**Consultation Response from KC,
Highways Development Management**

2023/92145 East Bierley Playing Fields, Hunsworth Lane, East Bierley, BD4 6PU

Date Responded: 23-10-2023.

Responding Officer: Mark Berry

Scale	1:100	Drawn By	ET
Drawing Size	A3	Checked By	PJM
Date	01/05/24	Approved By	PJM
Drawing Number		Rev	
152698-100-C1-0701

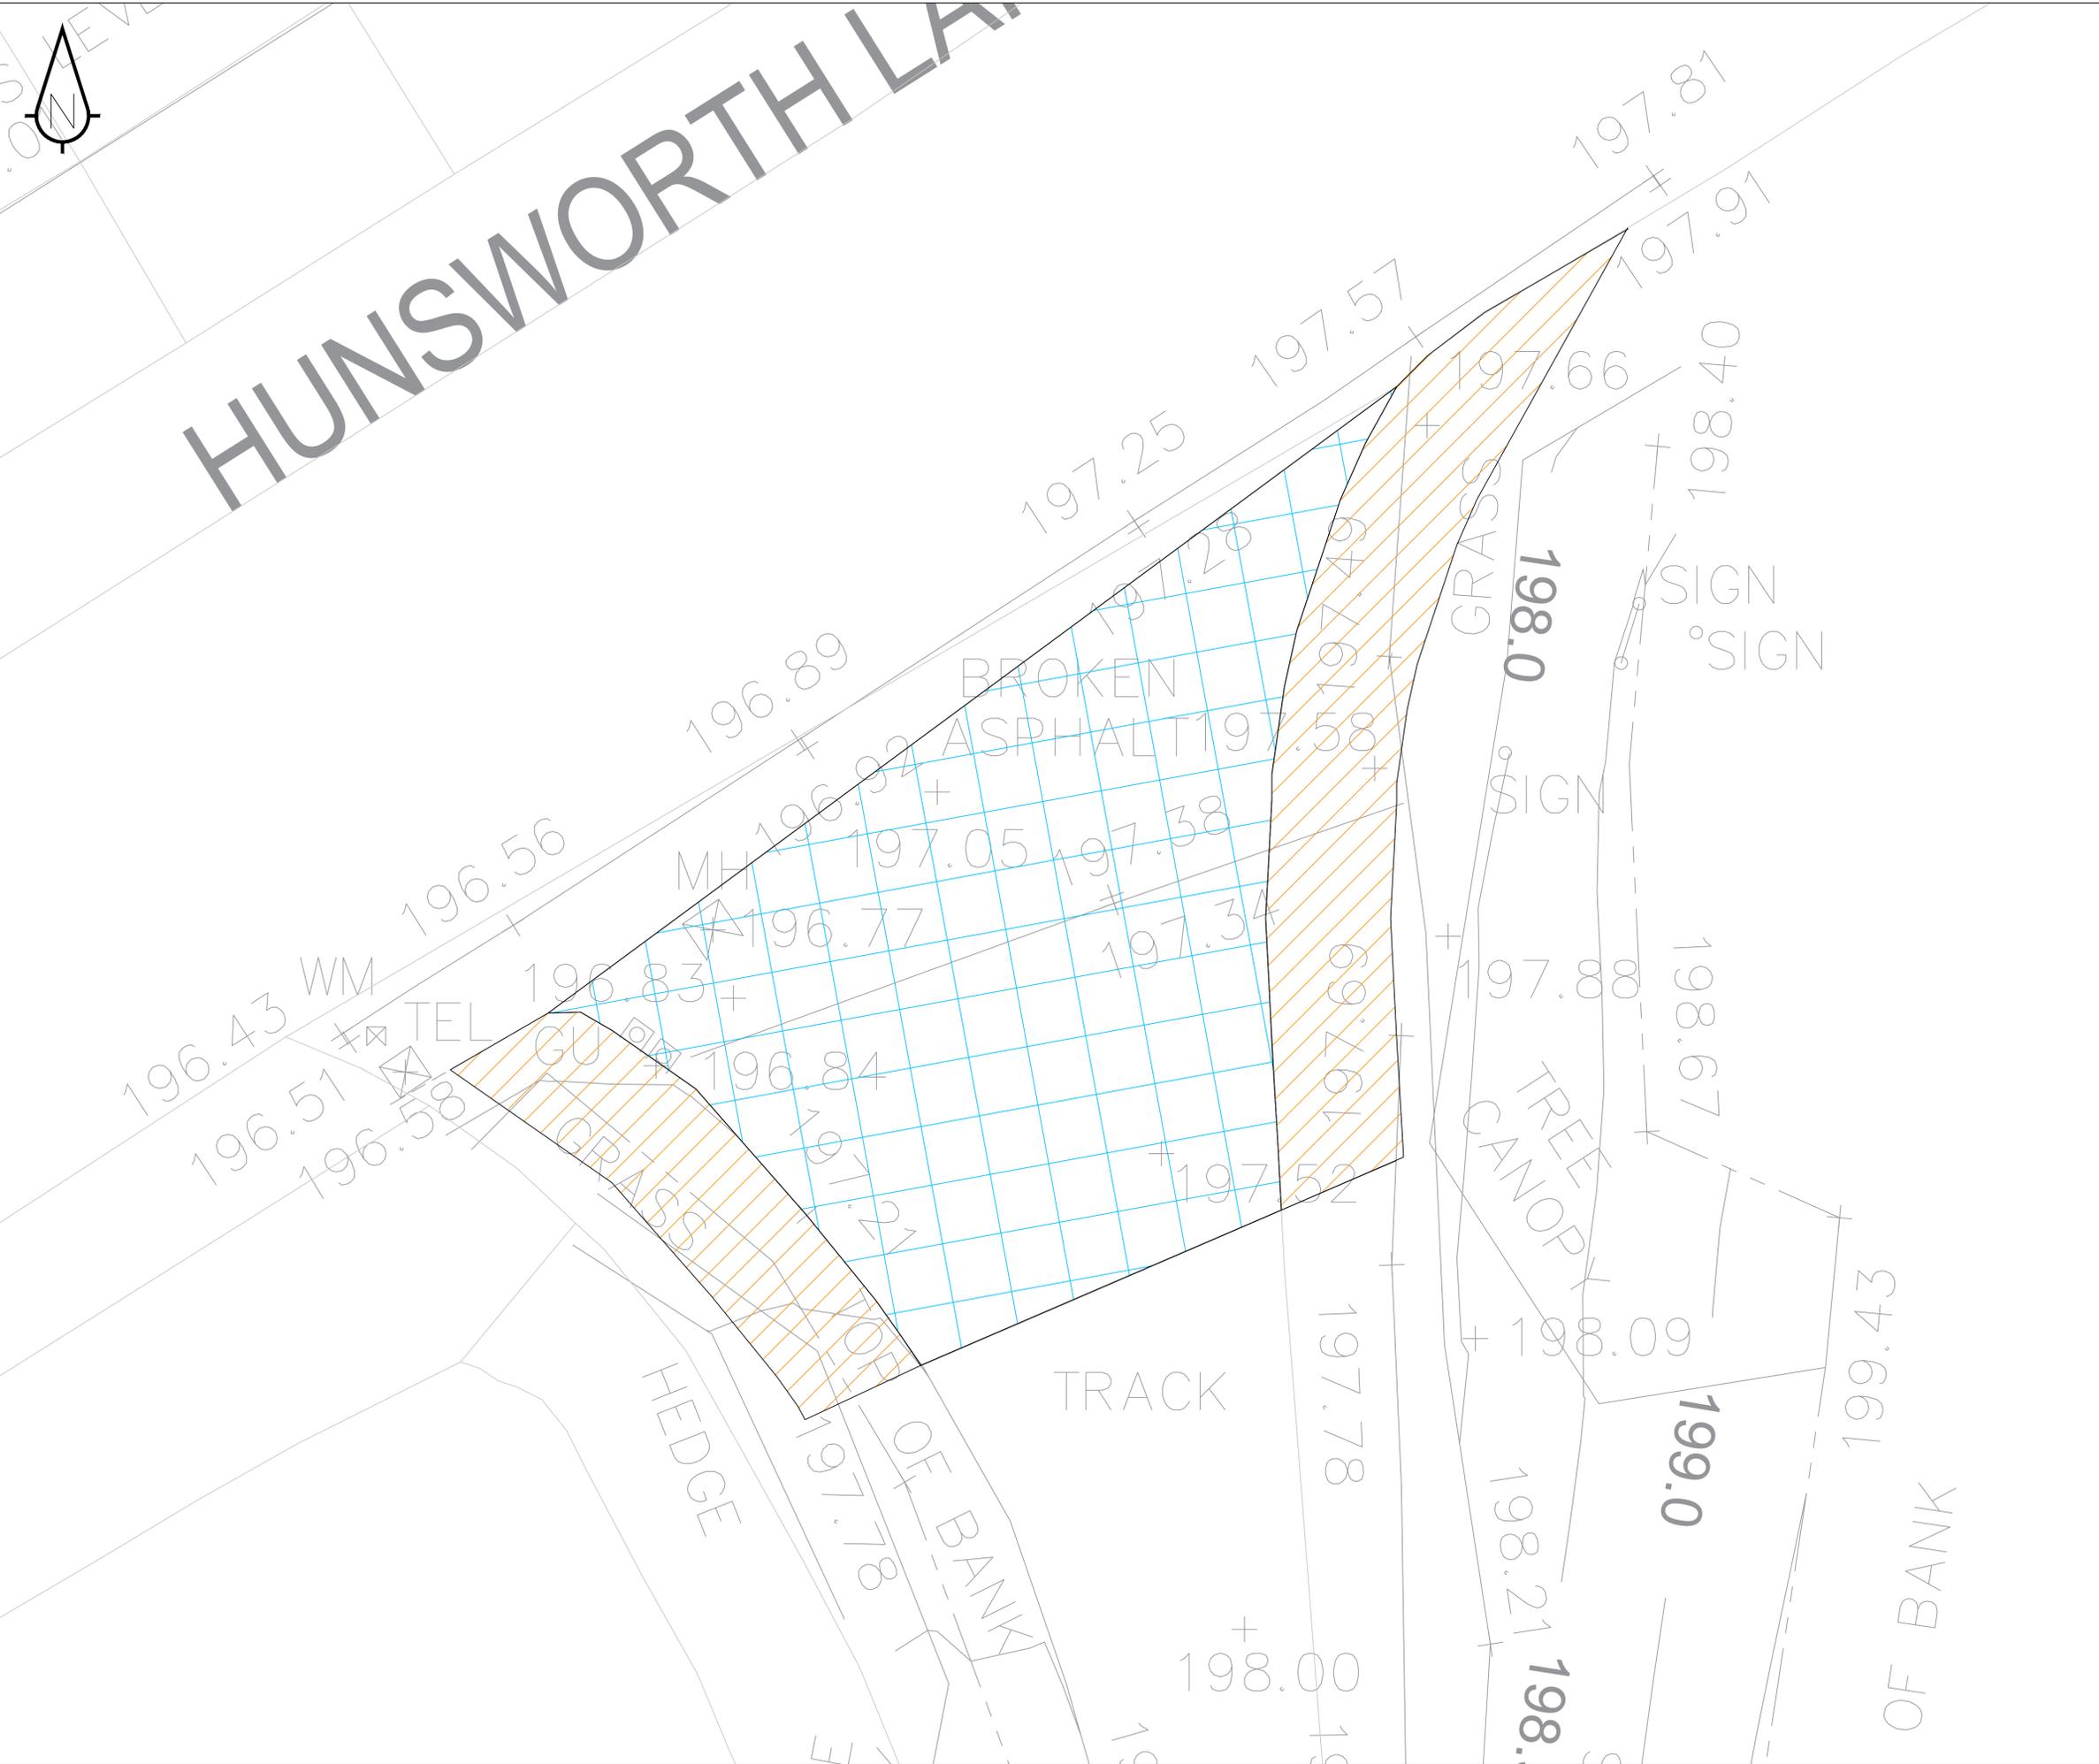
To discharge this condition the applicants have submitted Sanderson Associates plan numbers 152698 C5-0100 to C6-0200 showing an alternative scheme to that approved by 2019/93616. These plans show the realignment of the access, the provision of 6.0m radius kerbs, white lining at the junction with Hunsworth Lane (give way markings), carriageway surfacing to approximately the first 4.0m of the access track only, the provision of a short length of footway to the western kerb radii and then potholes filled to any previously un-gravelled areas of the access track.

These alternative proposals fall well short of the 2019/93616 application standards which included the provision of a new access road to adoptable standards including a 5.5m carriageway with 2m wide footways on both sides.

Given the significant reduction in standards can the applicants be asked to explain why they considered that their alternative proposals are sufficient and fit for purpose.
